DECISION NOTICE

Application Ref: FP/257/18/HH

16 Vicarage Lane
Felpham
PO22 7DZ

Alterations to form new 2nd floor with front & rear dormer projections - Resubmission of FP/104/18/HH.
This application affects the setting of a Grade 2 Listed Building

sheet 4 b of 6

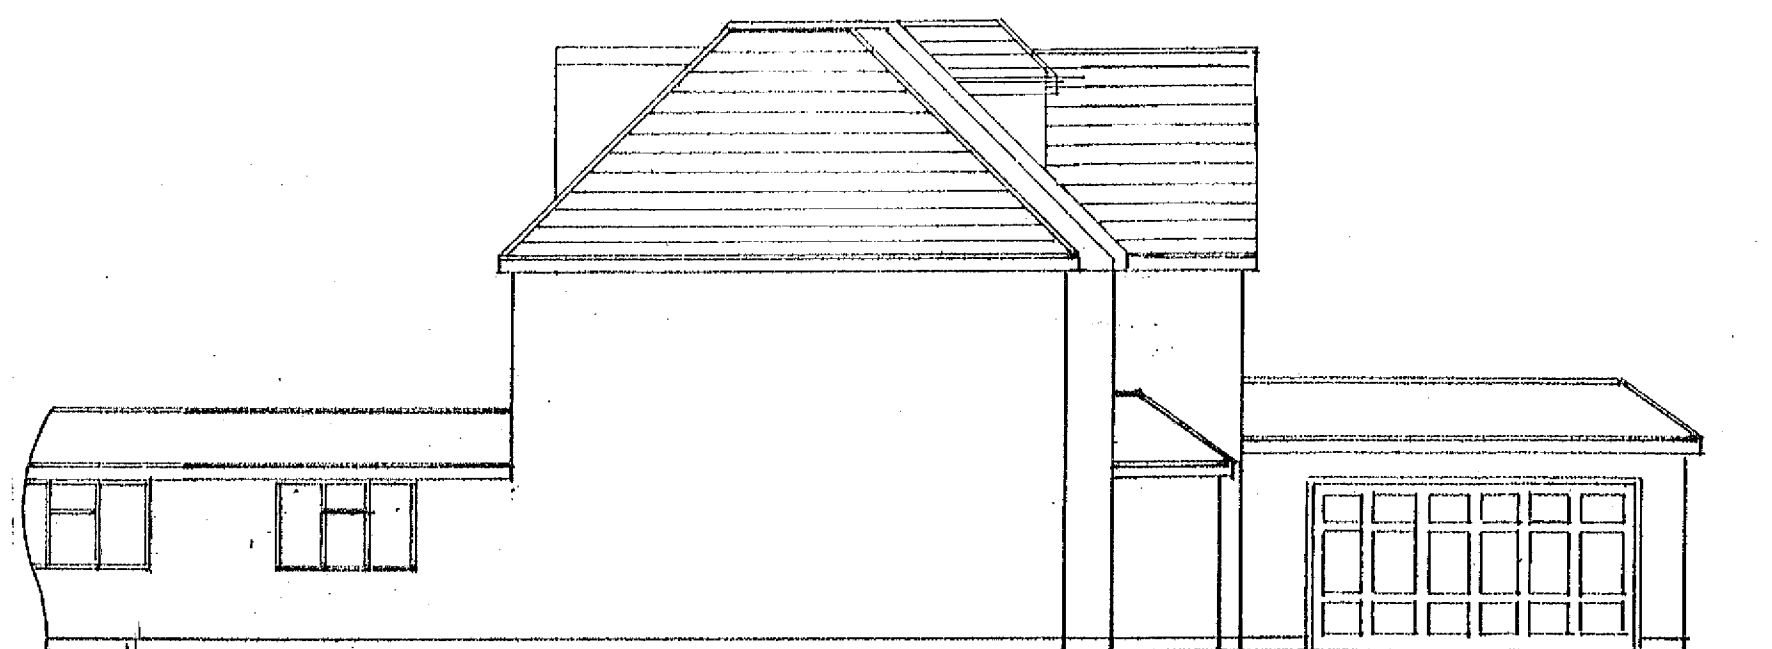
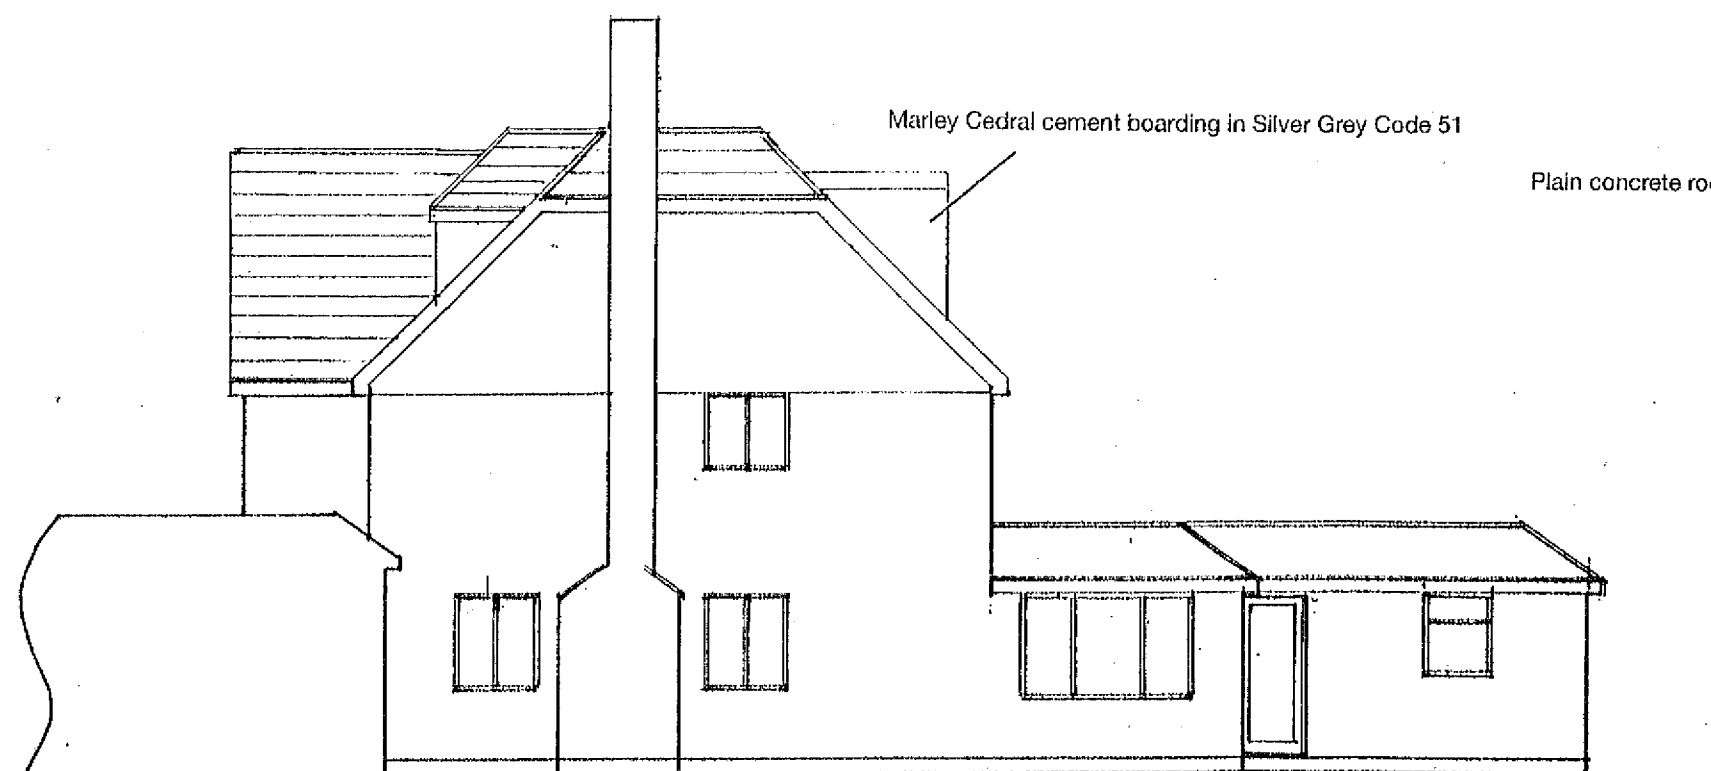
- 1 The addition of dormer windows to the front of the dwelling by reason of their size, number and appearance would cause less than substantial harm on the setting of adjacent heritage assets (designated conservation area and listed building). However in the absence of a heritage statement and any public benefits arising from the scheme the proposal is contrary to the NPPF, policies HER DM1 and HER DM3 of the Arun Local Plan and Felpham Neighbourhood Plan Policy ESD7.
- 2 The front dormer windows by reason of their size, number and appearance would cause harm to the character and appearance of the area contrary to policies D DM1 and D DM4 of the Arun Local Plan and ESD1 of the Felpham Neighbourhood Plan.
